Sea Link Energy Cable

**Natural England's additional comments regarding Landscape and Visual Impacts
including reference to documents included in REP1- 120 regarding acid grassland
proposals.**

Planning Inspectorate Reference EN020026

9th December 2025

- Suffolk Onshore Scheme Boundary
- Land Parcel

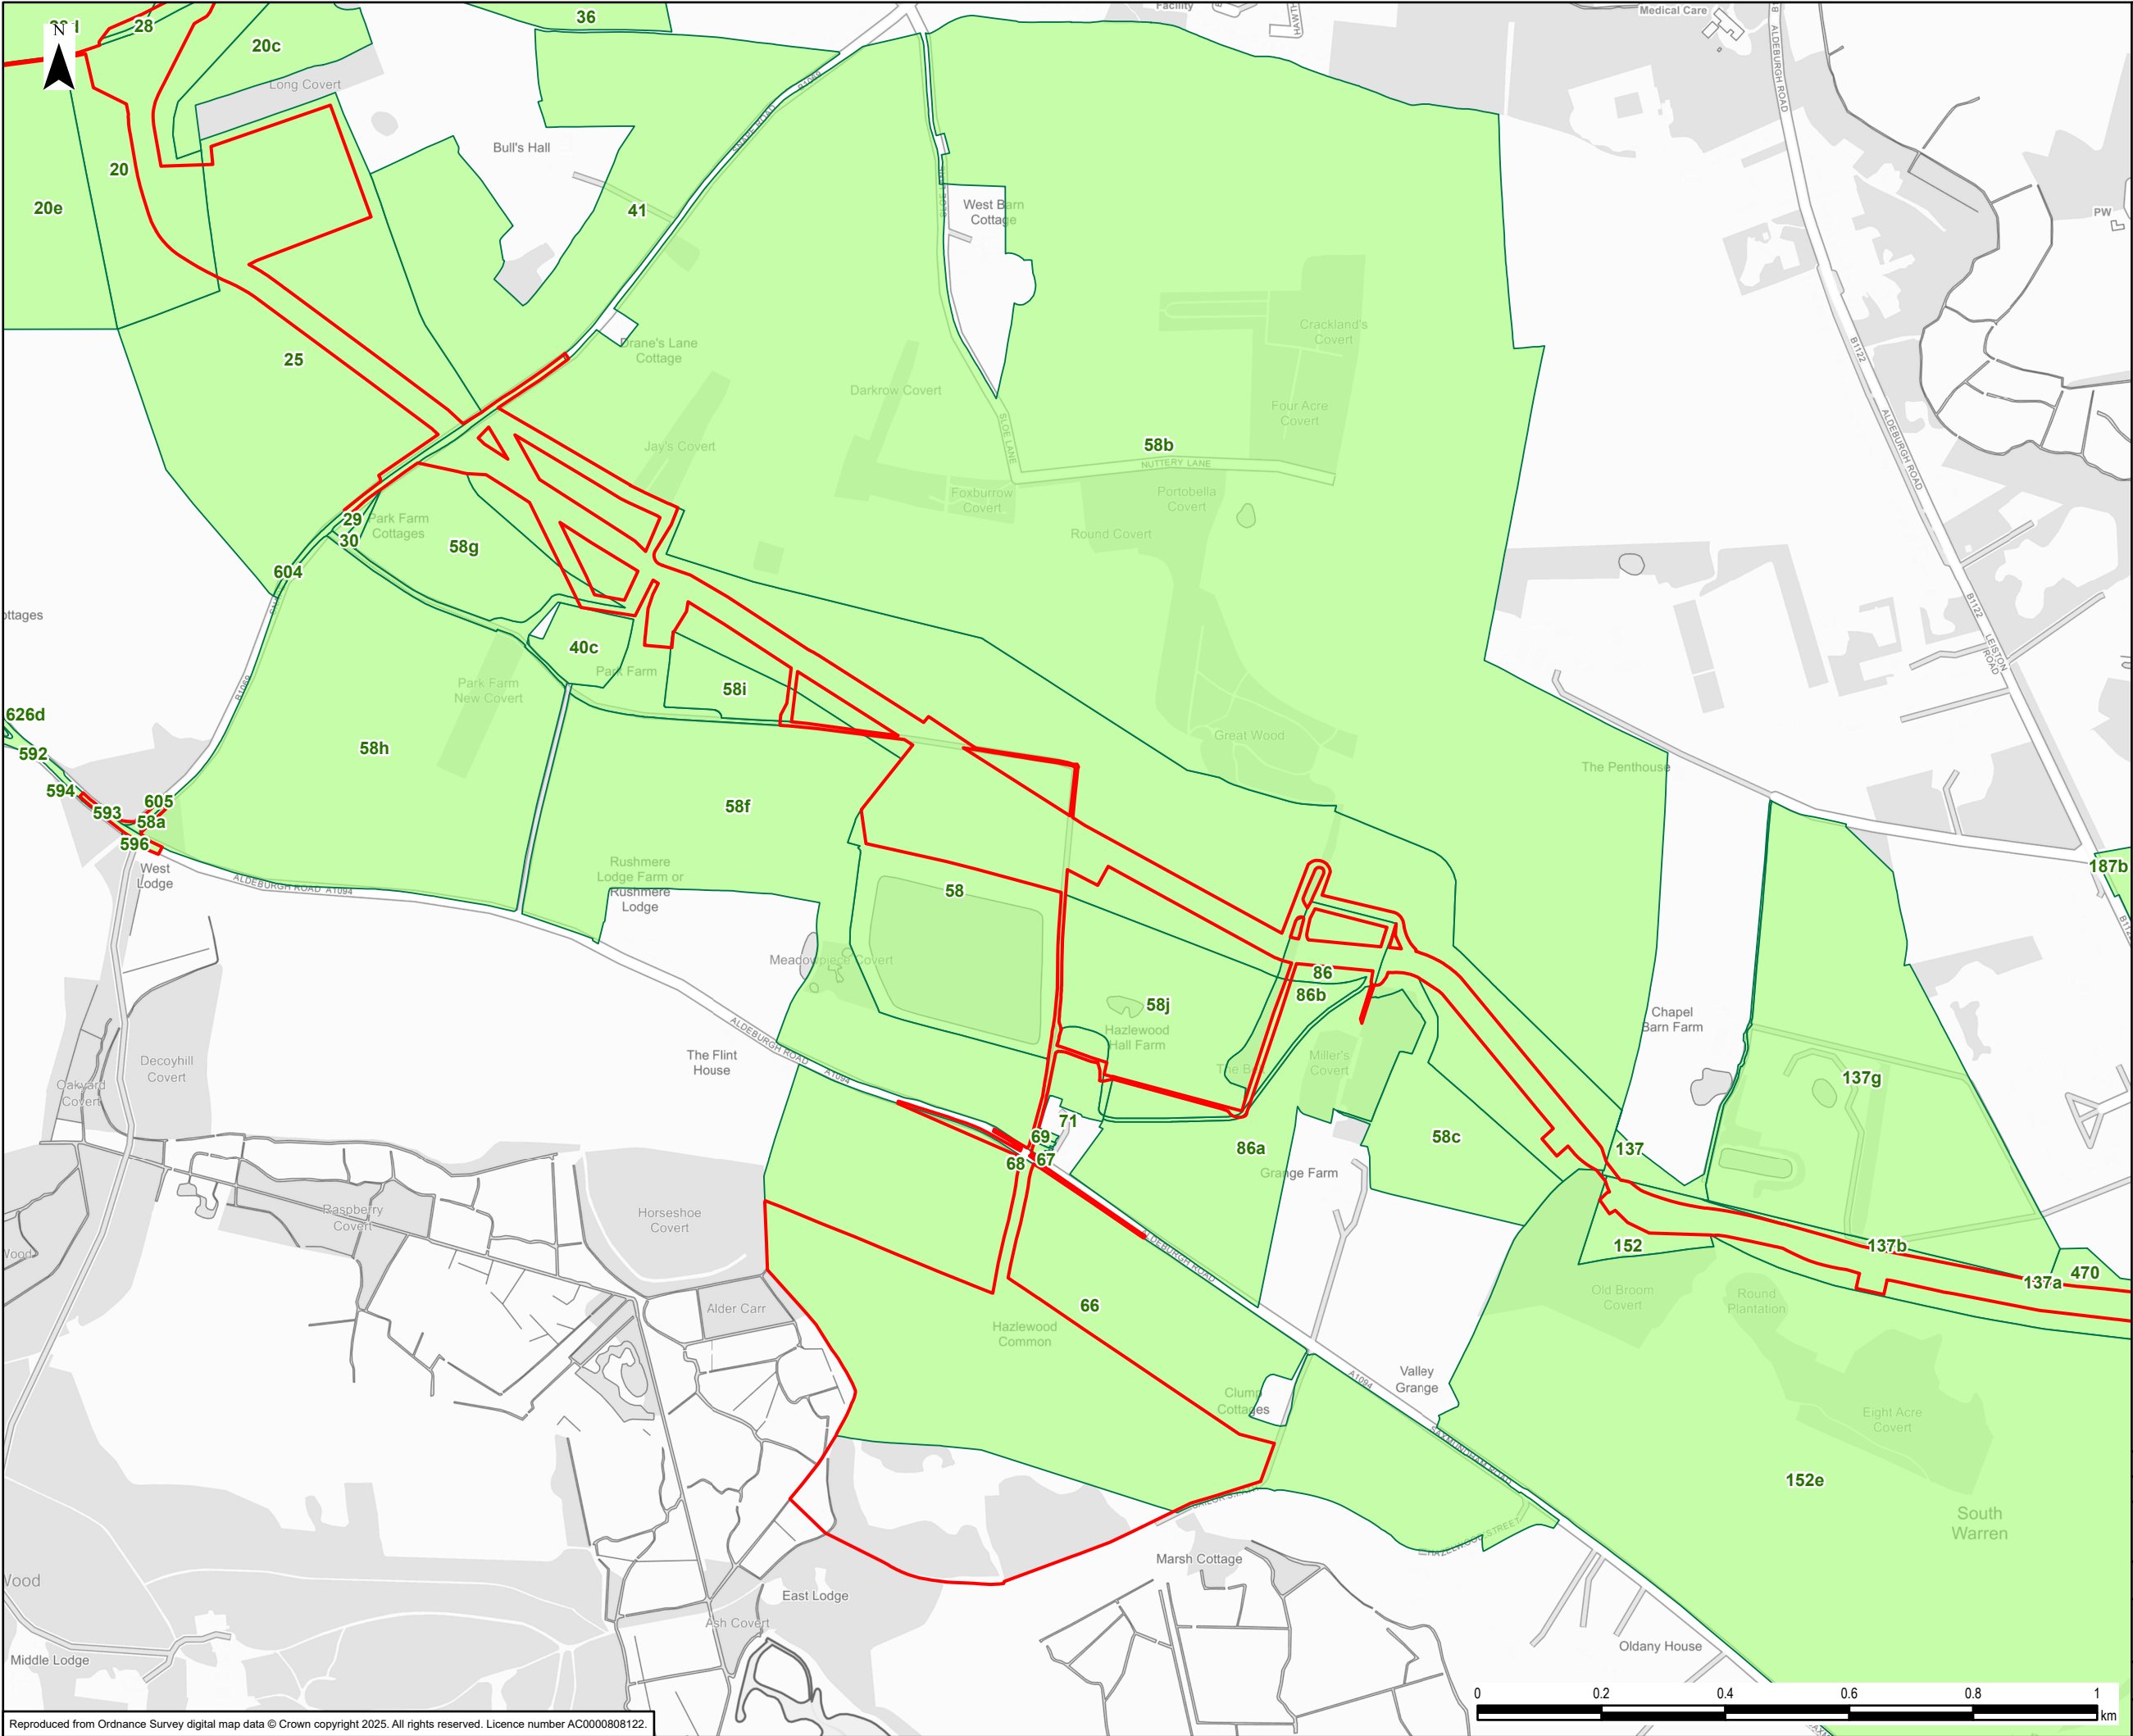
3	<p><u>Baseline botanical information</u></p> <p>Natural England note that paragraph 1.4.31 states that the “mitigation area” comprises “3.75 ha of semi-improved acid grassland” which is “species poor”.</p> <p>It is unclear what the quality of individual parcels are and whether they are semi-improved acid grassland or priority habitat. More botanical species information is required on all areas of acid grassland highlighted in the Phase I survey.</p> <p>It is unclear what time of year the botanical survey was conducted. It is crucial that acid grassland is surveyed in late spring/early summer to pick up the more uncommon species in this habitat. By mid to late summer these will no longer be visible.</p>	<p>Natural England advise that the Applicant should provide details on the condition of the acid grassland being temporarily lost, and details on when the botanical survey was undertaken.</p>

**Plate 3.2 Preferred area of acid grassland enhancement**

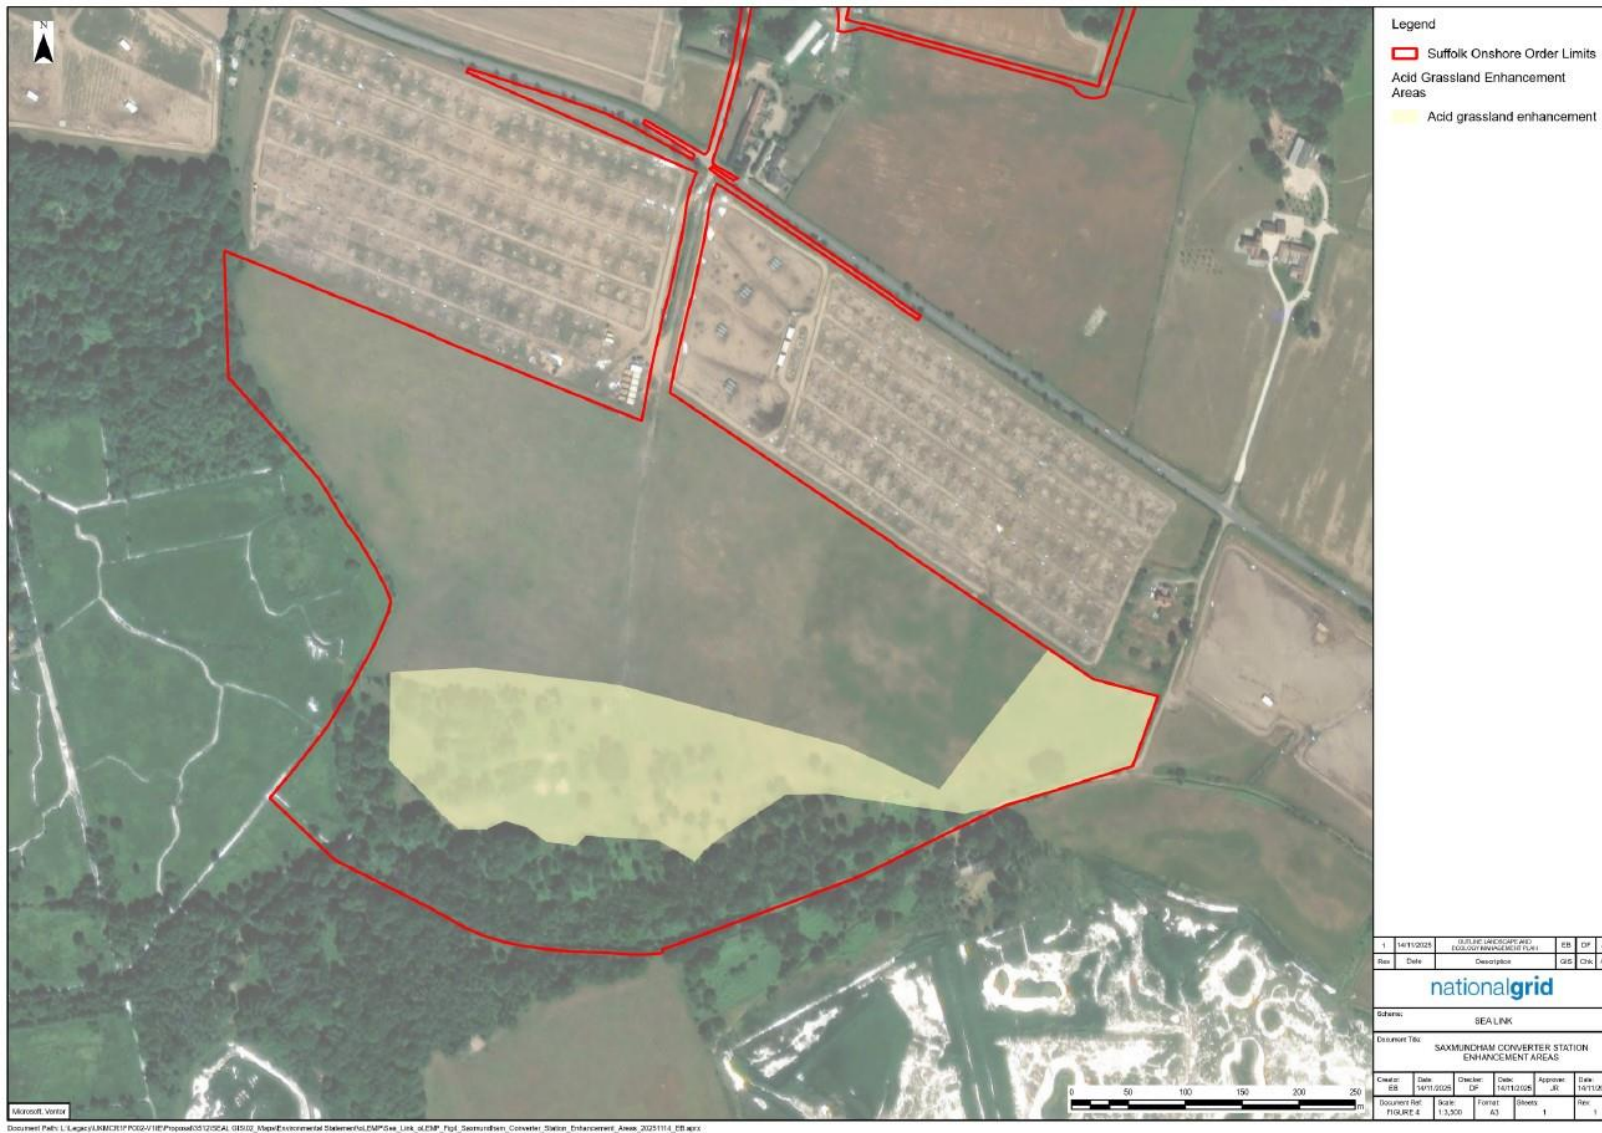
6	<p><u>Location of the acid grassland creation/enhancement</u></p> <p>Clarification is required on the specific location proposed for the acid grassland enhancement/creation. The area proposed is much larger than 6ha.</p> <p>If the flexibility is to allow for at least 6 ha acid grassland but the whole area will be restored to low fertility and pH land use (accepting that some areas may be more like neutral grassland) this may be acceptable.</p> <p>However, if the flexibility is to allow the landowner to continue with more intensive agricultural practices on parts of the restoration/enhancement site, this would compromise the likely success of the restoration.</p>	<p>Natural England advise that the Applicant explains why there is flexibility in the location of acid grassland creation/enhancement.</p>
